Subject: RE: LU/274/21/DOC - Croft Cottages, Littlehampton, BN17 5LS - UPDATED CONTAMINATION COMMENTS REQUIRED

The Contamination Mitigation Report does not constitute a satisfactory optional appraisal or remediation strategy, therefore parts 3 and 4 of the condition cannot be recommended for discharge. It will not be possible to recommend discharge of the entire condition until a separate Verification Report is provided on completion of groundworks on site (to include soft landscaping).

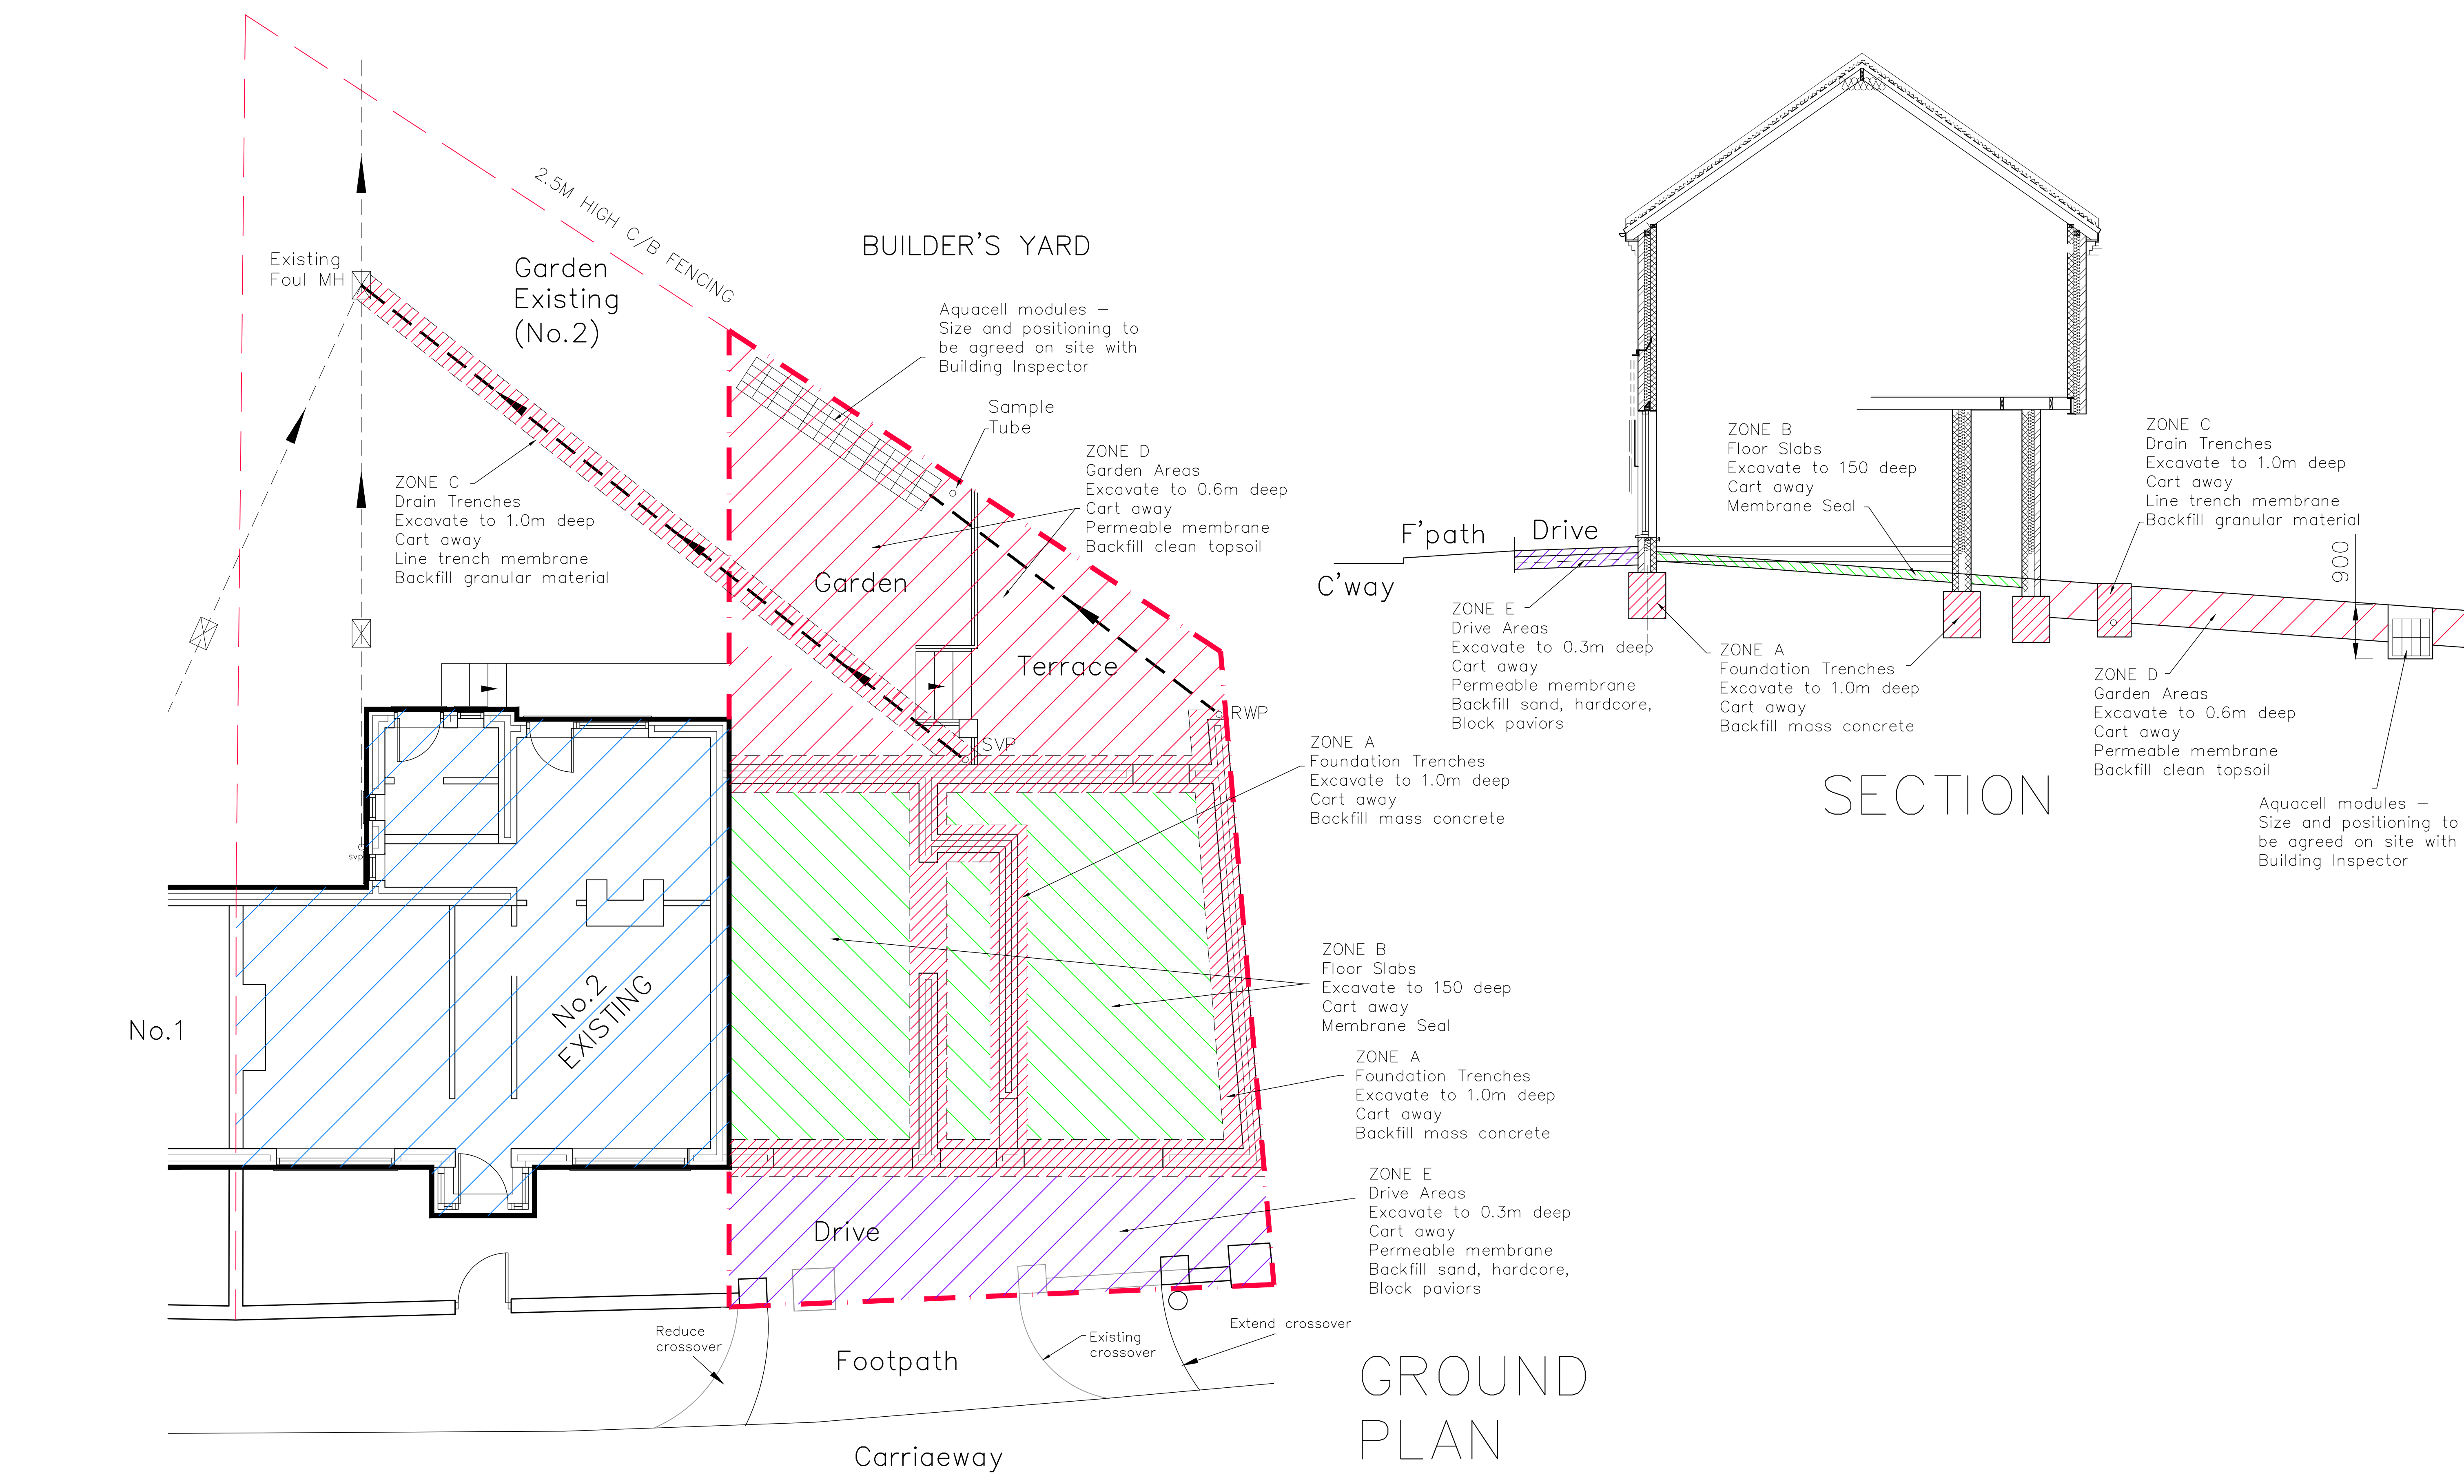
It is recommended that the Environment Agency is consulted with regard to the provision of soakaways in relation to the condition of the land.

#2
The intention of the Aquacell crates is that they will act as soakaways. Our starting premise is that the contaminated soil is to be removed, and with a working tolerance to the excavated depth, the source of contamination will be removed. Given the constricted nature of the site and the fall to the rear of the site, we consider the crates proposal to be the 'least worst' option. Southern Water Catch Pit 7851 to the north west is a negative fall from the site, and the storm sewer in Clifton Road is 60m to the east across private land. We also note that currently there is no formal storm drainage or water management on the site, with potentially contaminated run off passing, unrestricted, under the rear fence to the adjoining yard. Southern Water map extract attached.
